City of Albuquerque Stormwater Construction Site Inspection Report

ESC File No.	L20E075	Project Name:	JB Henderson New Fabrication Facility		
NPDES Id. No.	NMR1003Q6	Location:	10200 Bell Avenue SE		
4/6/2021	Owner	Contractor			
Operator	Trumbull Development, LLC.	JB Henderson			
Contact name & title	John Stroud	John Stroud			
e-mail	jstroud@jbhenderson.com	jstroud@jbhenderson.com			
Contact Phone #	505-292-8955	505-292-8955			
COA Inspector	Thomas Evans	Start/End Time:	2:35 PM		
Construction Phase:	Pre-construction				
Type of Inspection:	Regular	Storm Event	Past Storm Event >0.25"	311/Complaint	Follow Up
Weather at time of inspection?	Clear	Temperature:	~	72	
Estimated date of last storm 0.25" or greater	2/22/2021

TEMPORARY EROSION AND SEDIMENT CONTROL PLAN

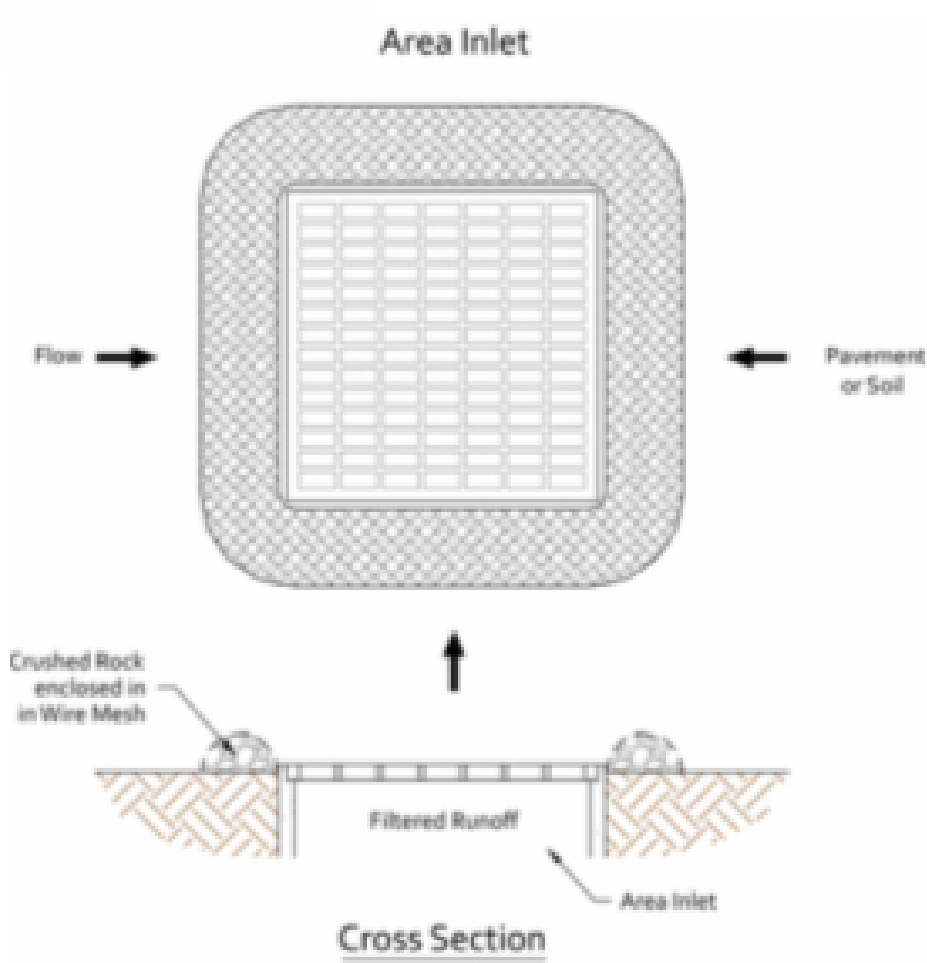
Item Number	Deficiency/ Corrective Action			
1	NPDES permit sign not posted.			
2	Silt fence in a couple areas needs to be fully erected at the ends.			
3				
4				
5				
2.1	Discharge off site? (Y/N)	no		
4	Self Inspection Reports	Requested	Latest report Date:
